Responses to ExQ1

Application by Highways England for A63 Castle Street Improvement Hull

TR010016

3 6.2 Environmental Statement Volume 2 Figure 10.2 (APP-036)

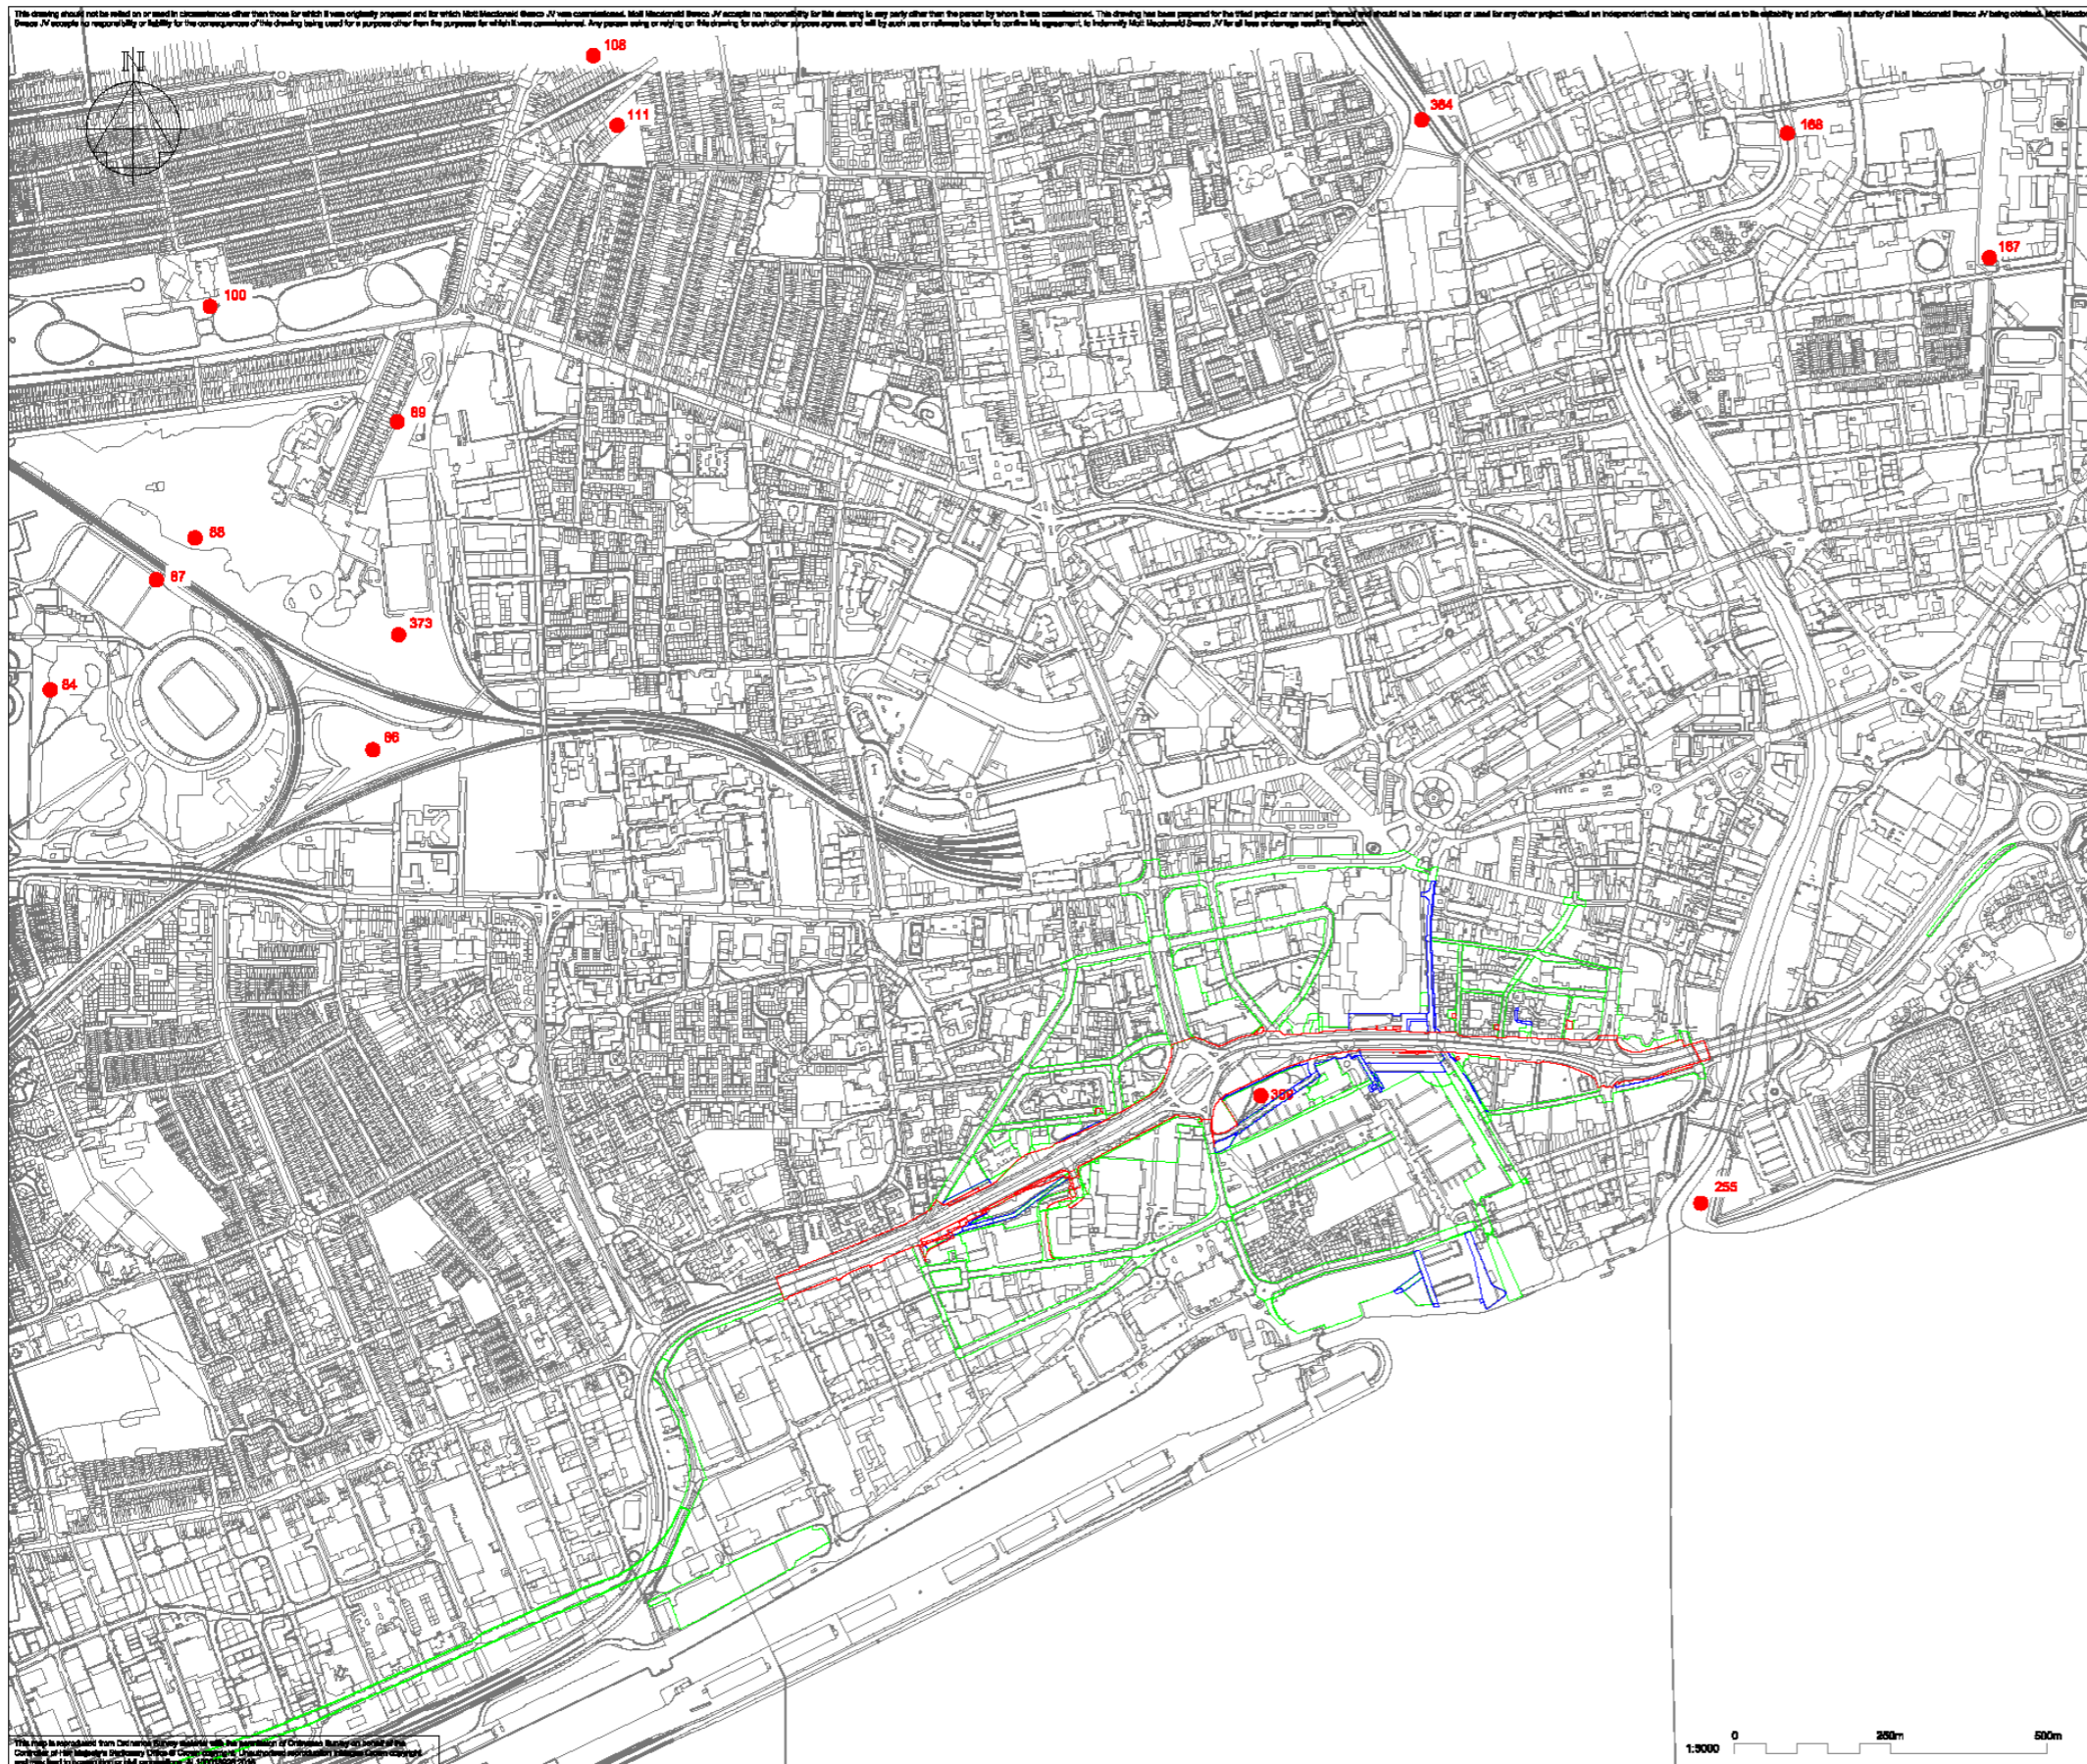
1.2.2.	Applicant	<p>Non-statutory Sites The key on the Environmental Statement Figure 10.2 (non-statutory designated site) is incorrect, as already mentioned within the S56 advice. Please provide a new Figure 10.2 to address the issues identified at acceptance.</p>	
	Applicant	<p>Non-Statutory Sites Not all non-statutory sites located within 2Km of the Proposed Development have been included in the assessment. For example, the mudflats to the south of Sammy's point is discounted but it is located only 250m from the Proposed Development. Please explain the rationale for this.</p>
